SUBMISSIONS REPORT:

Proposed Residential Flat Building including In-fill Affordable Housing

12-16 Bent Street, Lindfield
Lot 3 DP1226294, Lot 1 DP935936, Lot 1 DP960015, Lot 1 DP318518 & Lot 1 DP960014

13 October 2025

Title
C1-ELEVATIONS
E-W ELEVATION

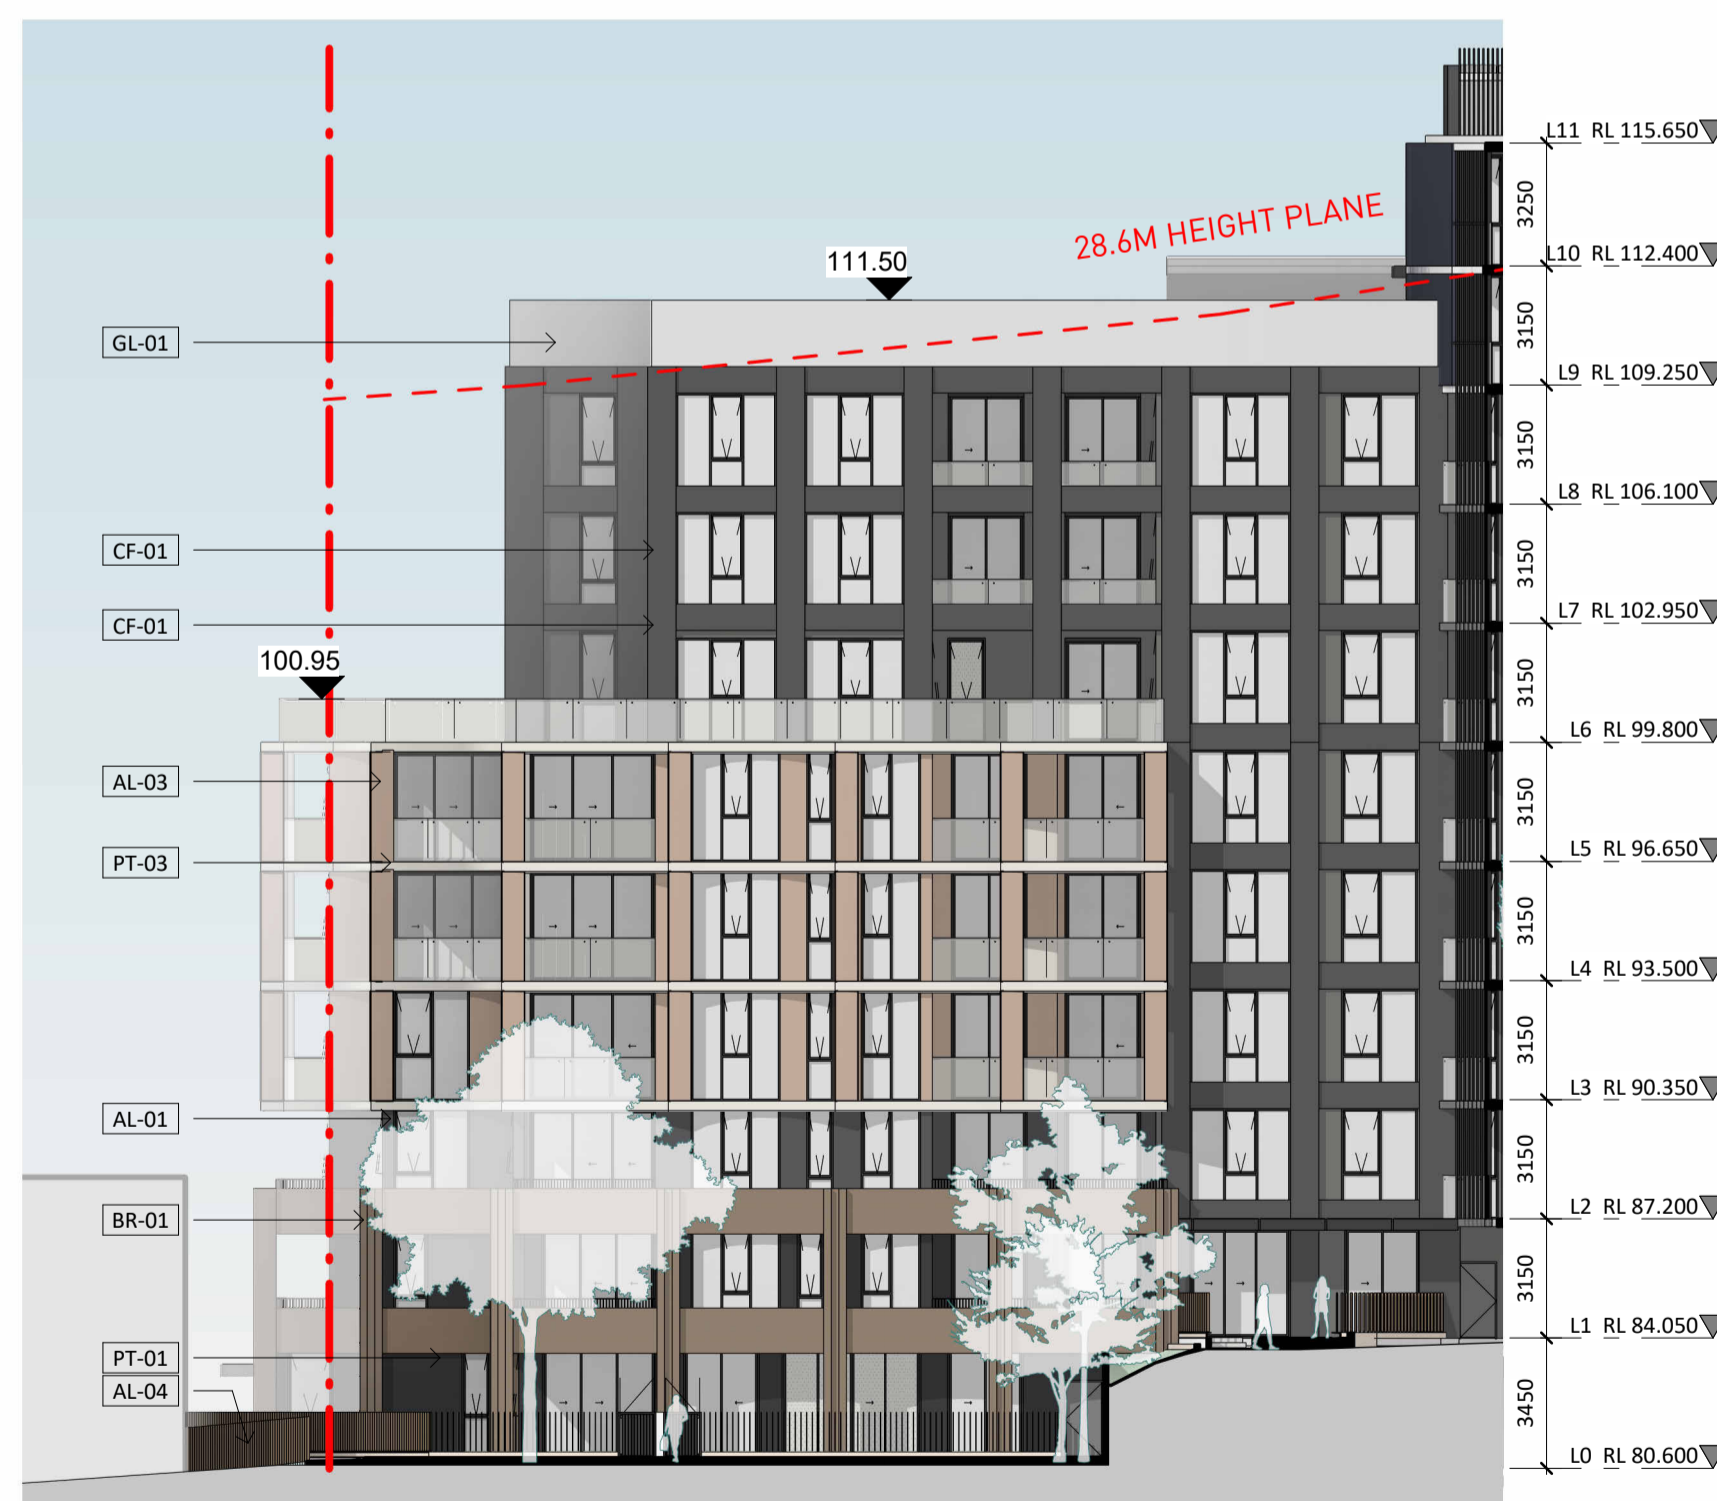
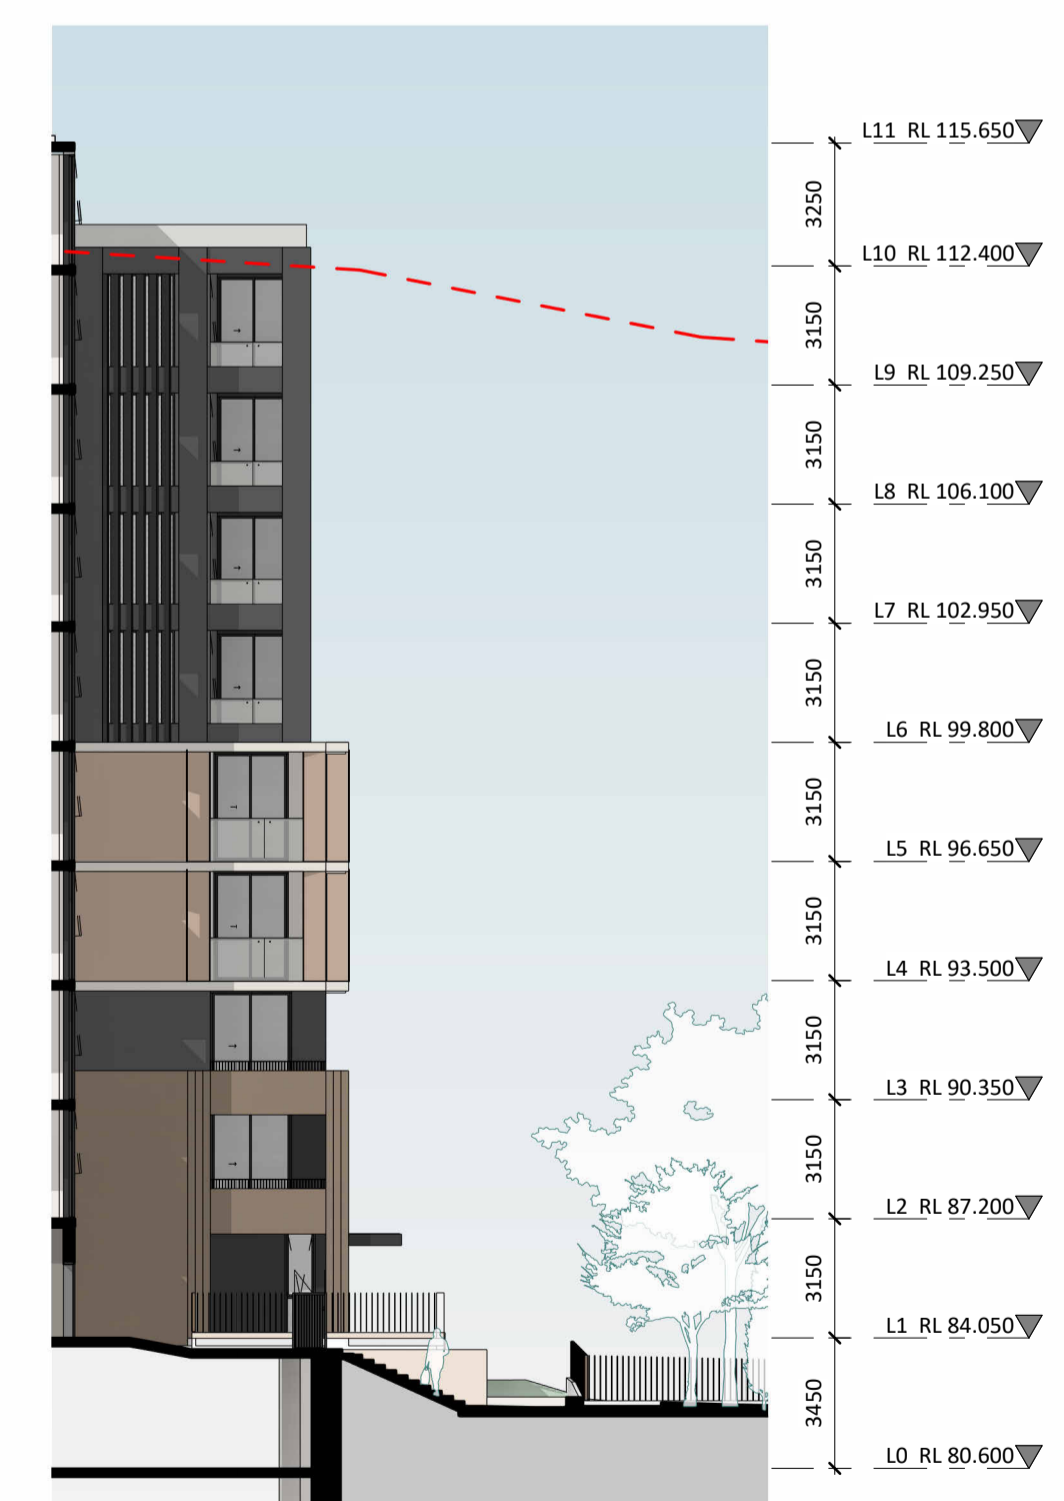
I note that SDRP recommended an increase in height on the northern portion and transitional height on the south-west. However, this should not lead to a height breach with a full floor above 28.6 m.

The height breach coupled with the encroachments within the setbacks implies that the site may not be suitable to accommodate the full GFA that is proposed. In other words, the site may not be suitable for a 3.25:1 FSR.

and 78 units with at least two (2) hours solar access representing 70.3% compliance. Amenity compliance is demonstrated through 1,174m² communal open space and 30.8% deep soil provision, while the strategic justification shows the height variation enables housing diversity and affordable housing cross-subsidisation that strict compliance would prevent, with an estimated 15-20% yield reduction under a compliance scenario.
